Planning Act 2008 (as amended) – Section 51

Application by Gate Burton Energy Park Ltd for an Order Granting Development Consent for the Gate Burton Energy Park.

Advice following issue of decision to accept the application for examination

47 Rue Maurice Flandin,  
69003 Lyon FRANCE  
contact@skyrayengineering.com  
<https://www.skrayengineering.com/>

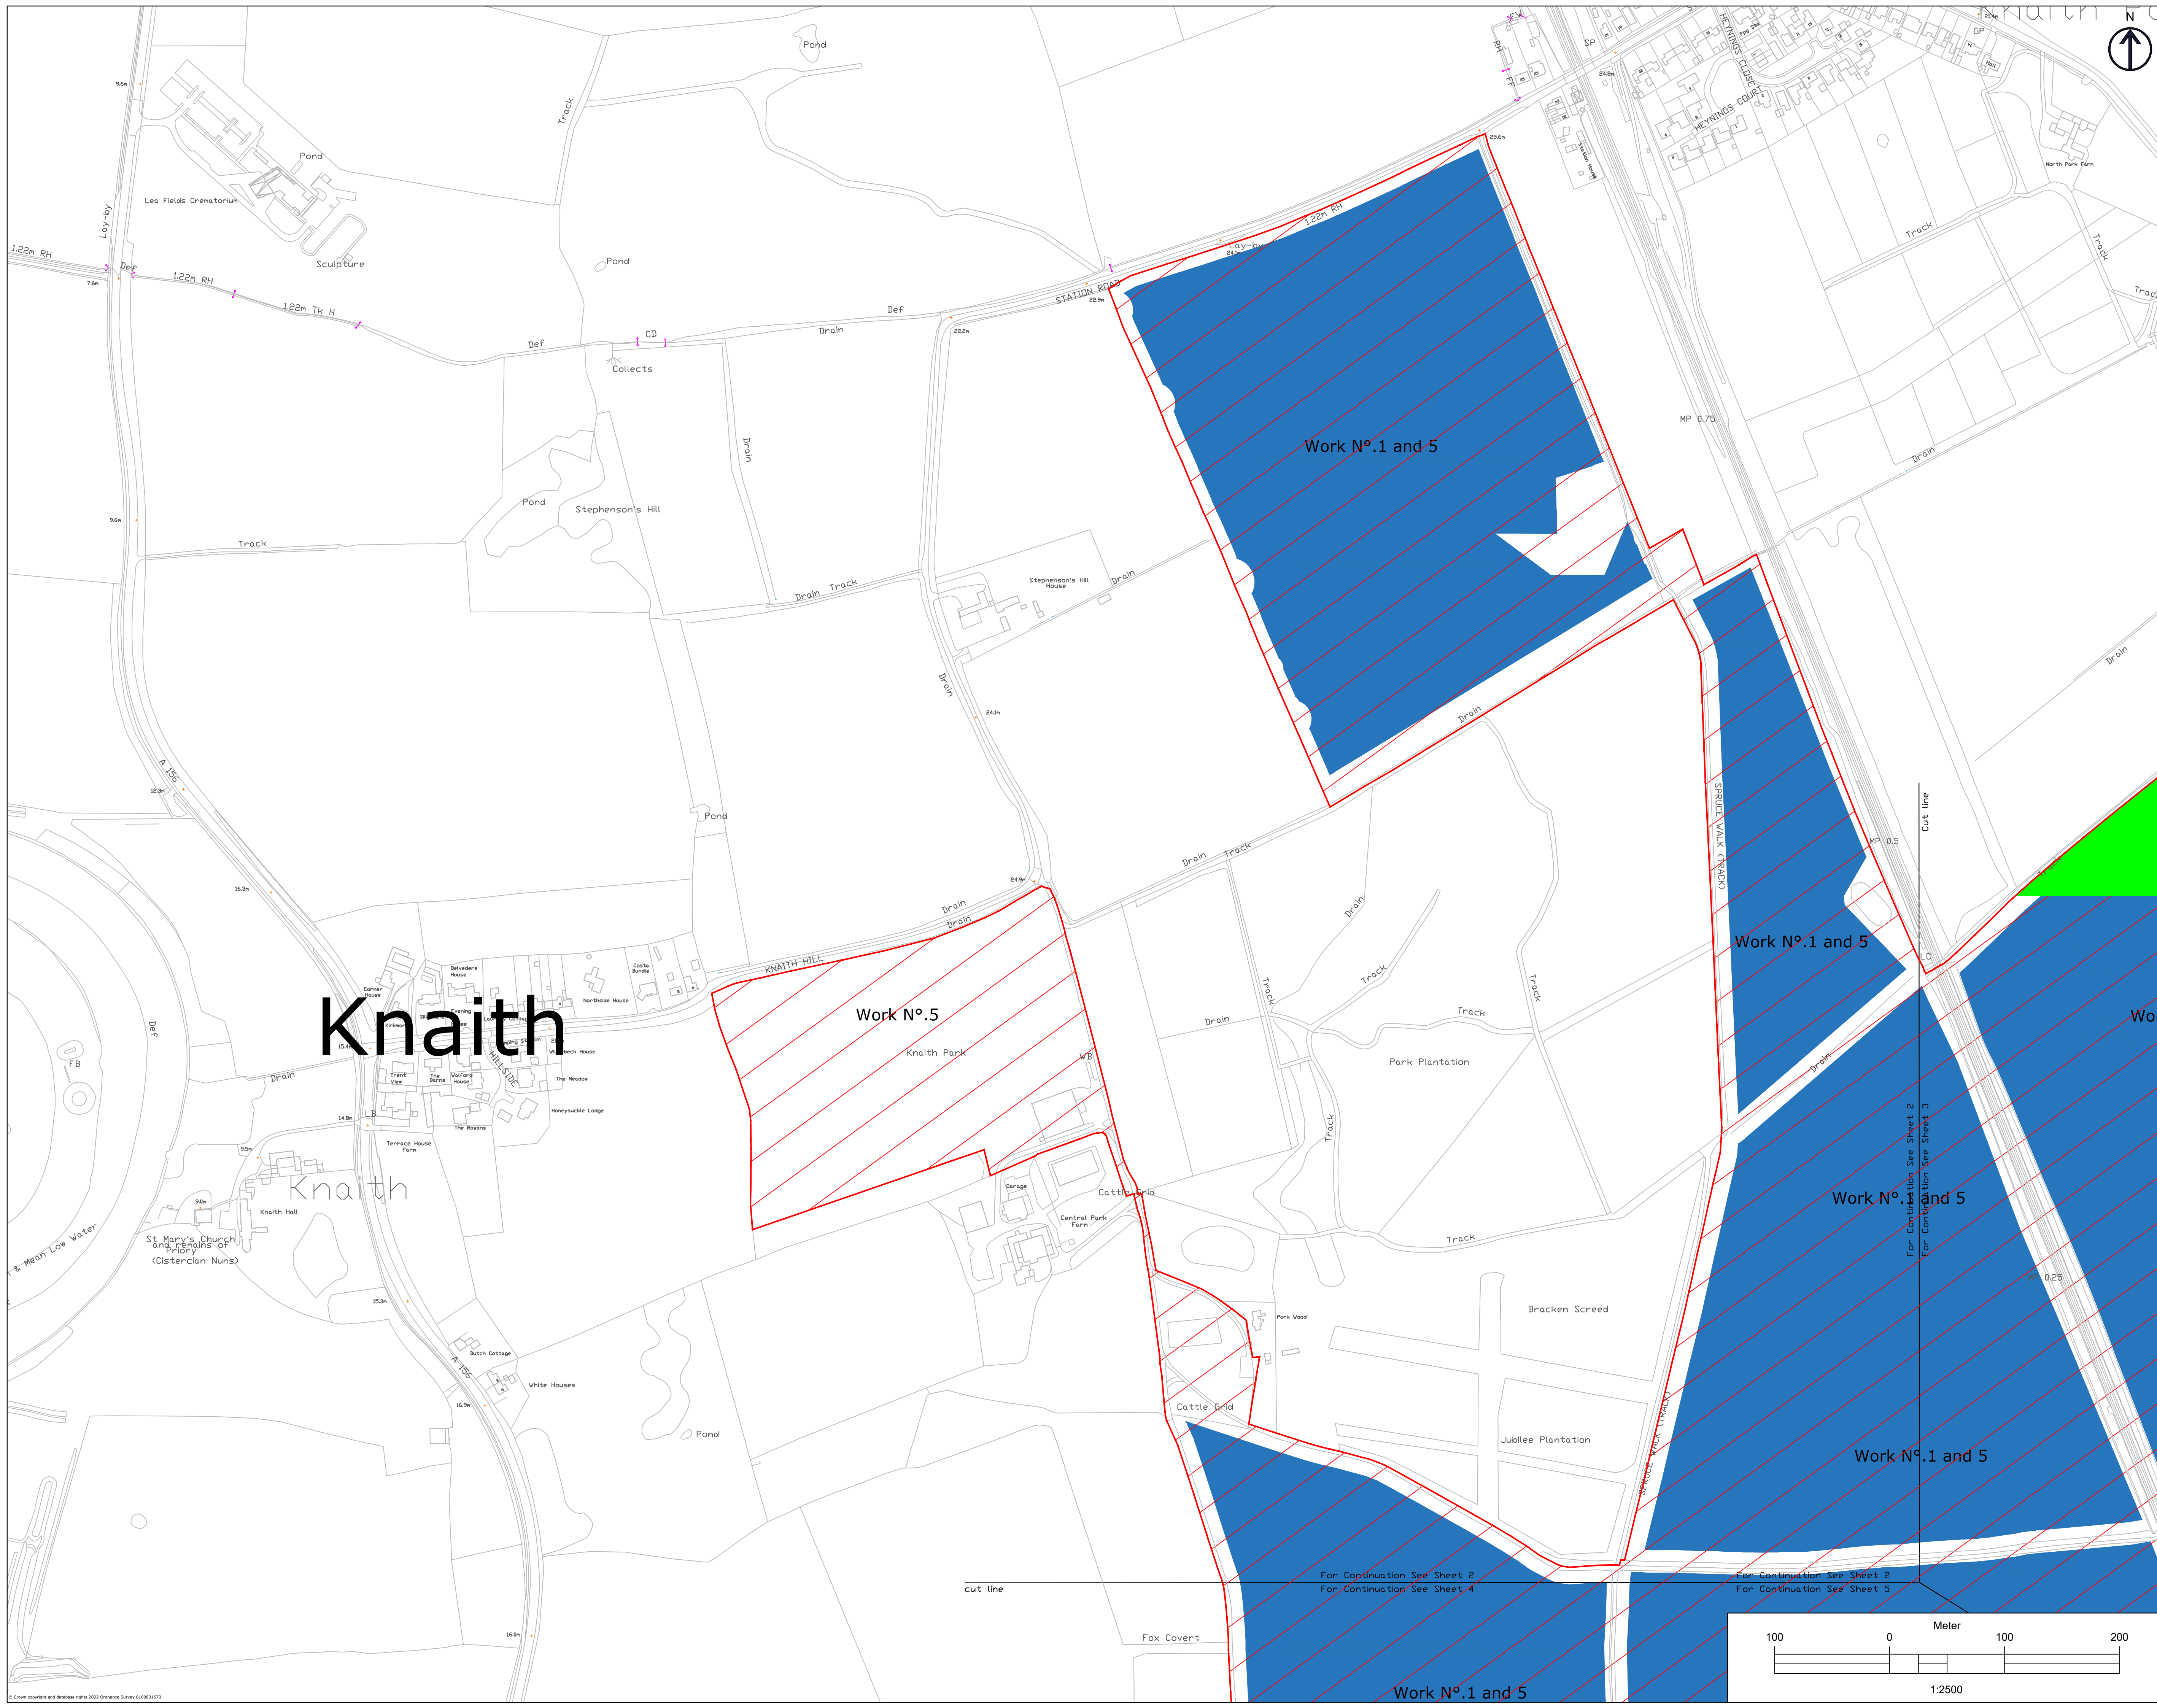
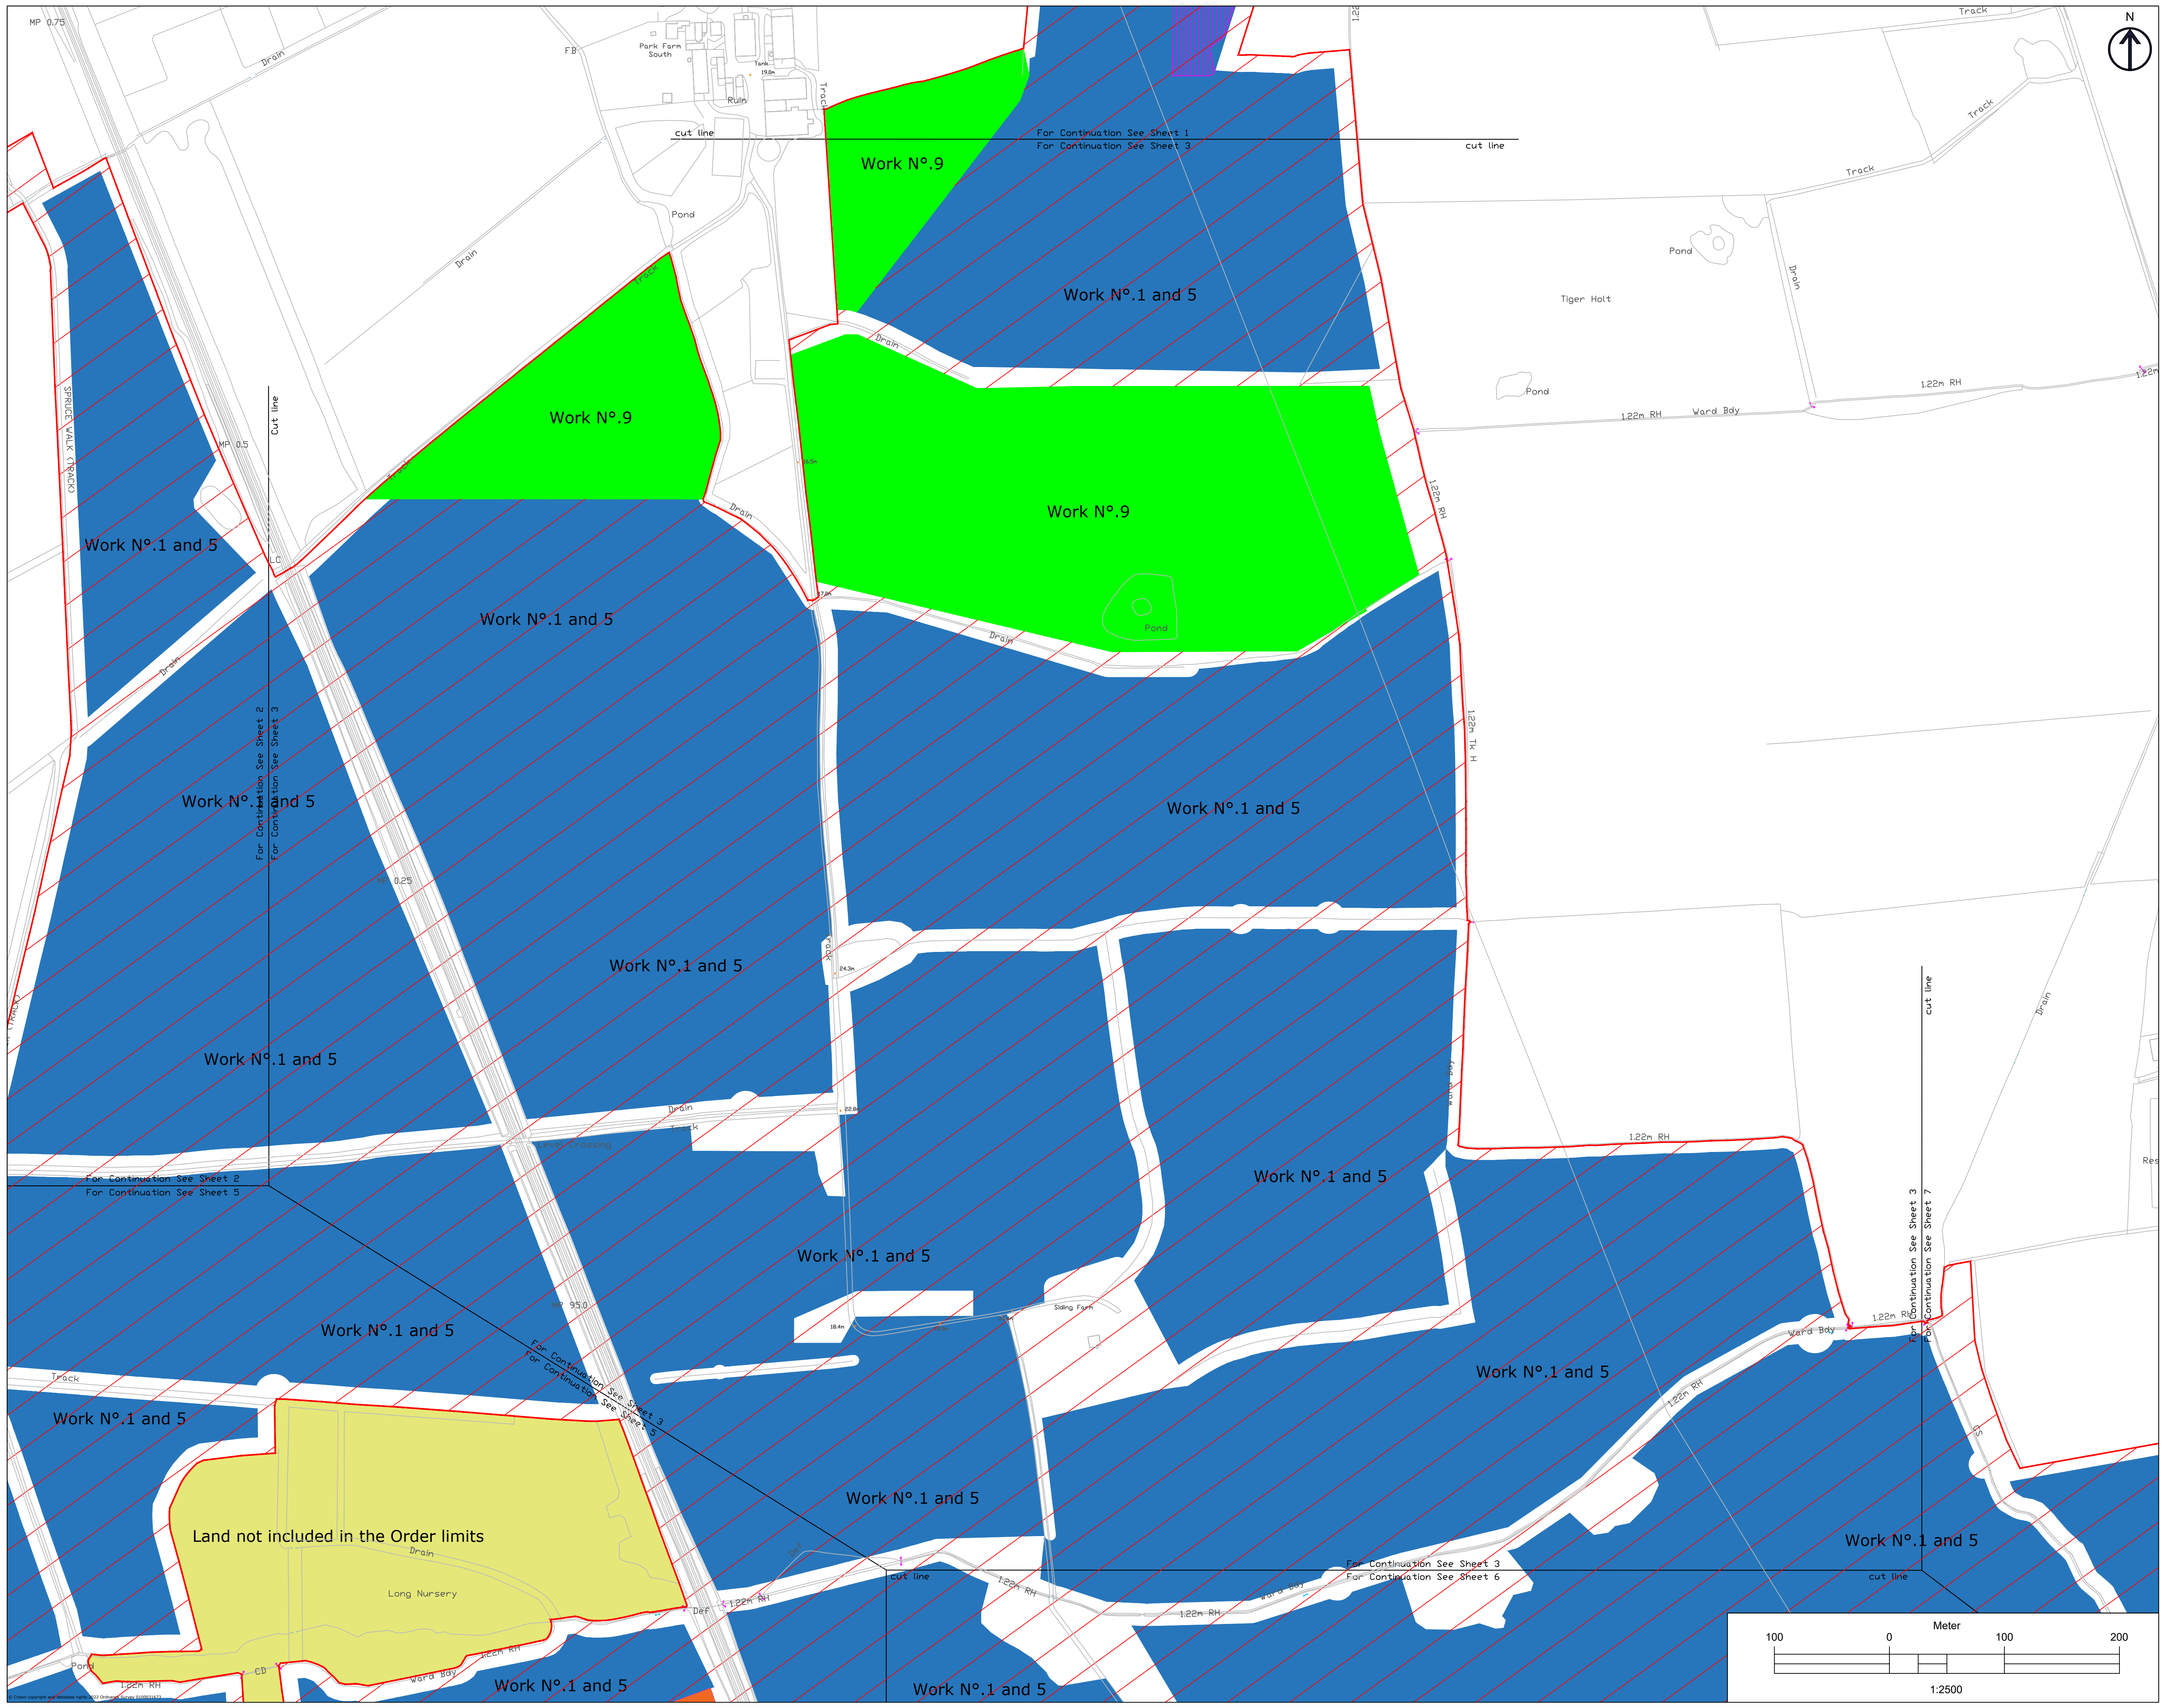
The Applicant is advised to conduct a consistency check between the Legend and the plan. For example, alphanumeric annotation is used on Works Plan but is not included in the Legend, and the colours used in the Legend do not collate well to the plan, for example, the yellow in the legend is much brighter to that used on the plan.
